PCD Project Manager_2026-06-10_006 - Letter of Intent.pdf Markup Summary

Planner (1)

SITE DEVELOPMENT PLAN FOR HONOR CHARTER SCHOOL

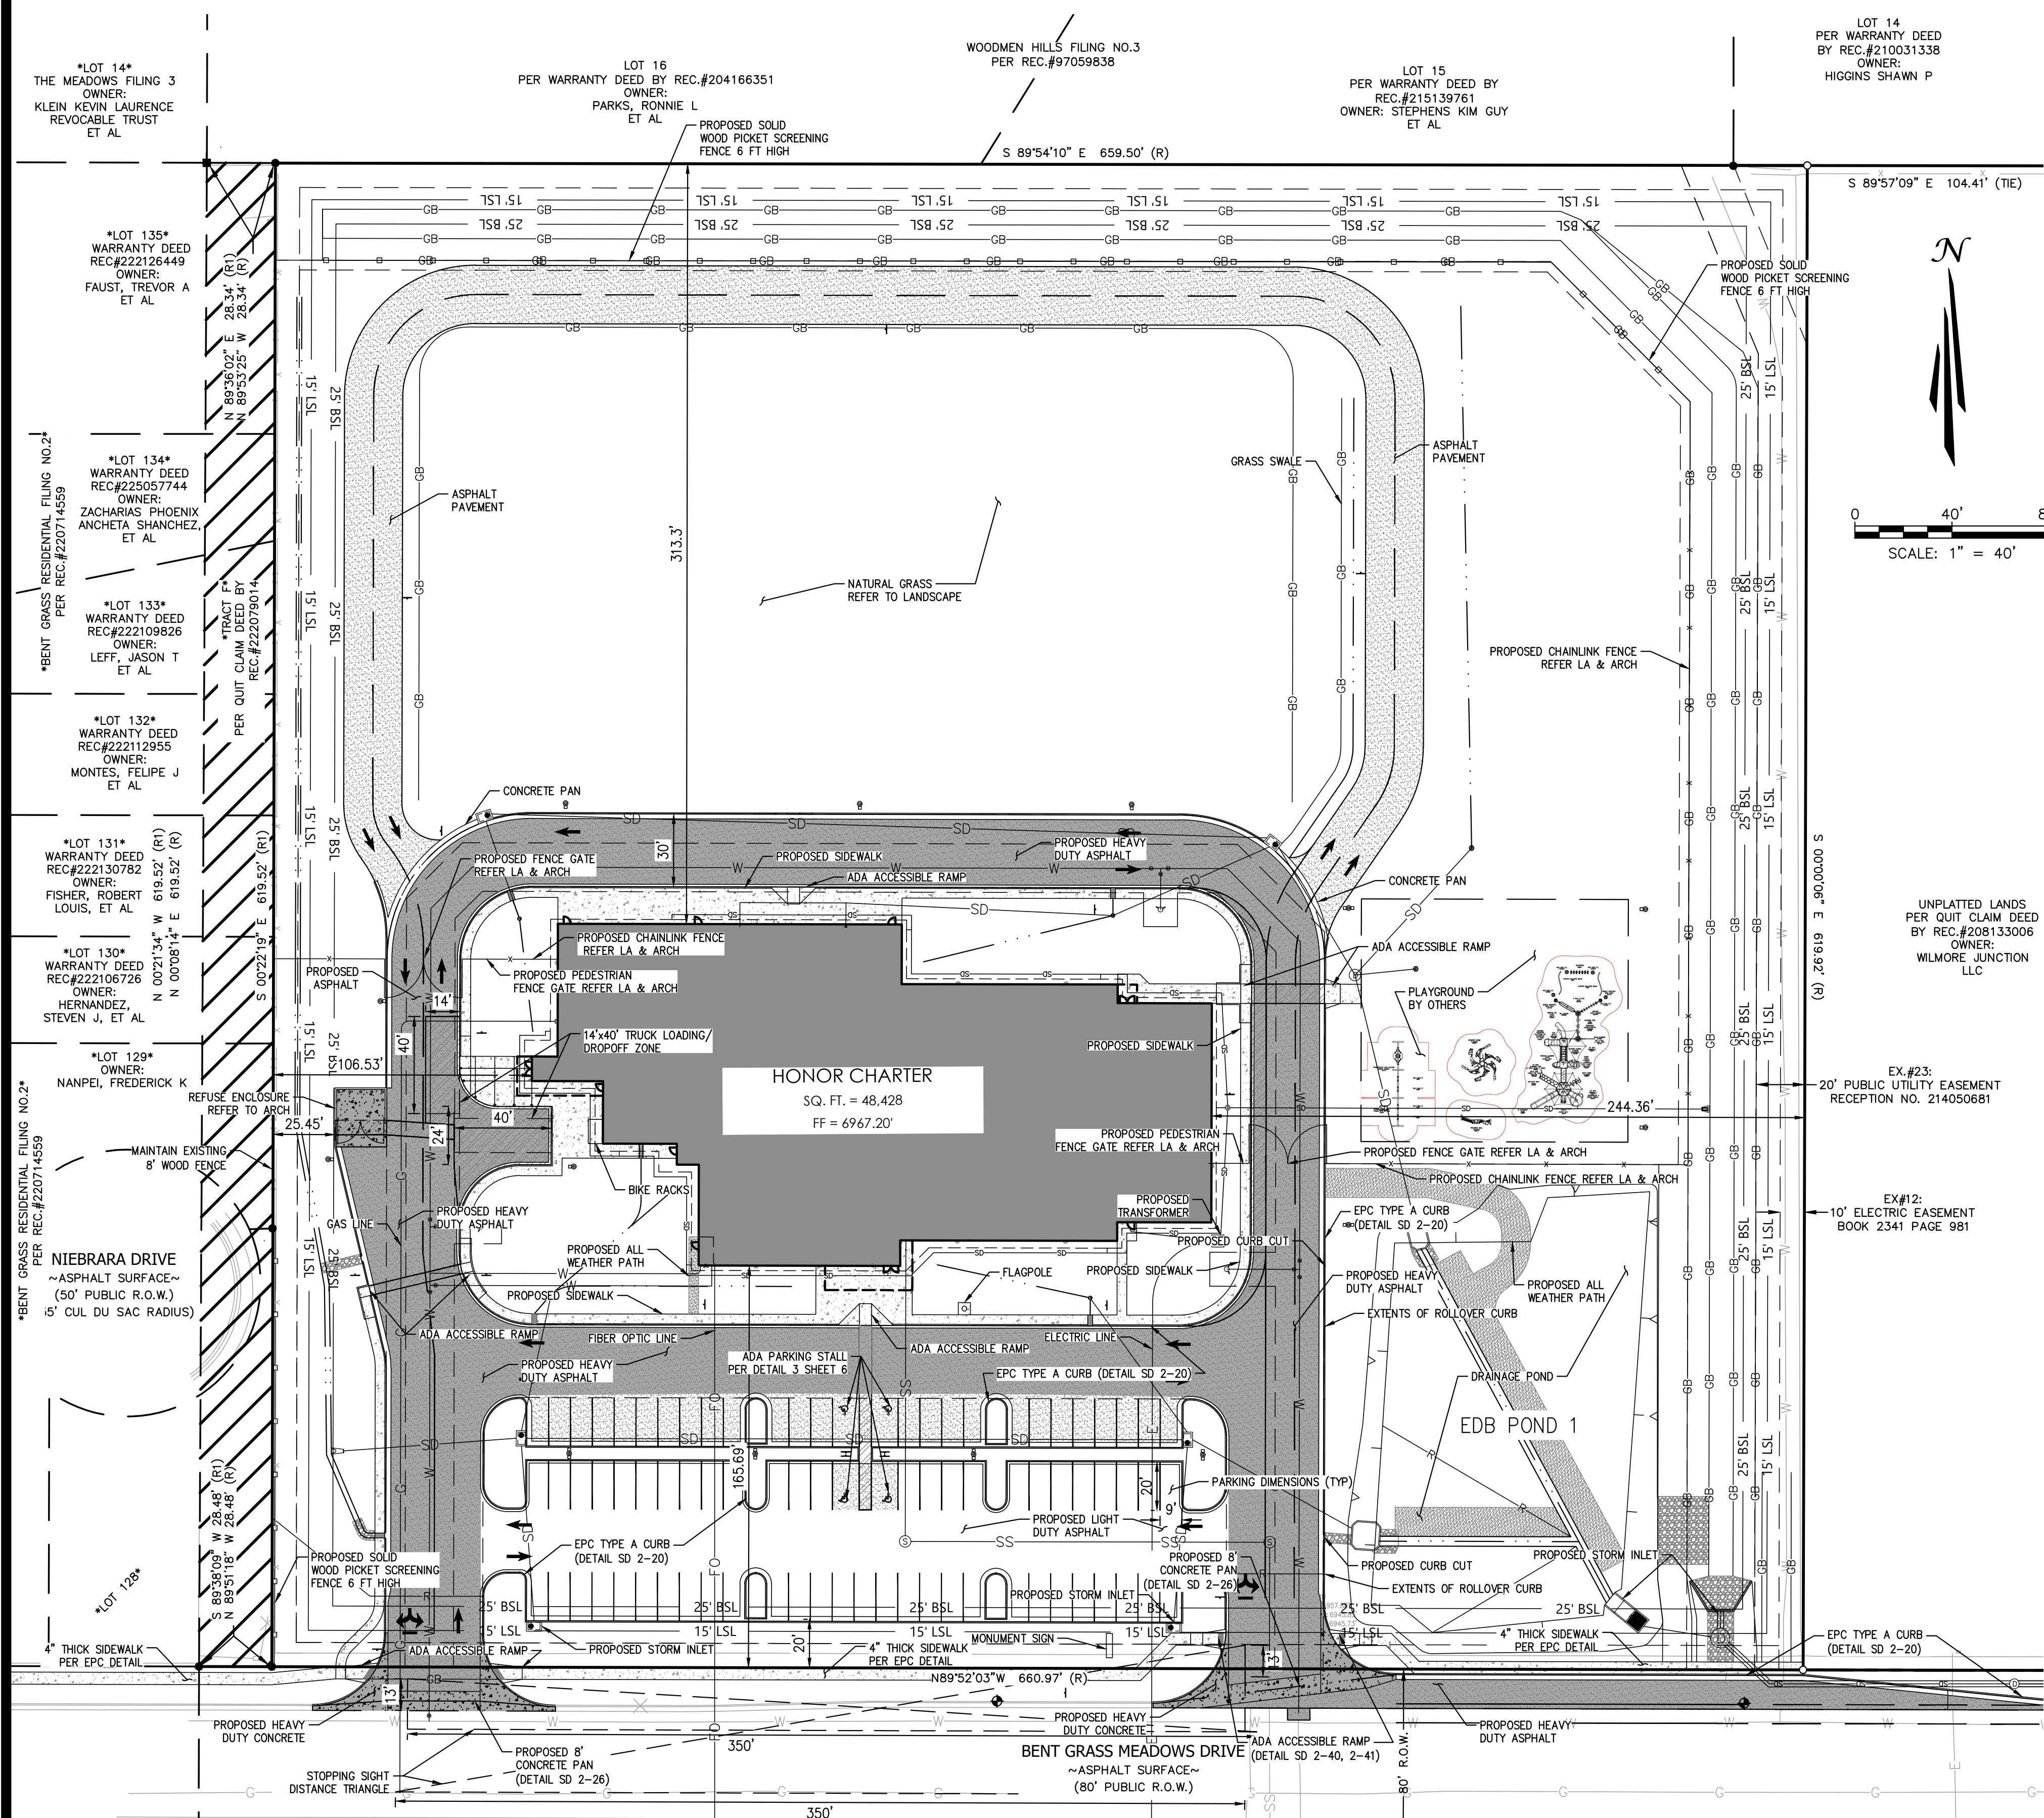
Please include a section for Road Impact Fees. Road Impact fees are charged by the following for the Woodmen Road Metro District: \$1.10/sf x 48,428sf = \$53,270.80

RESPONSE: THIS HAS BEEN ADDED TO THE DOCUMENT.
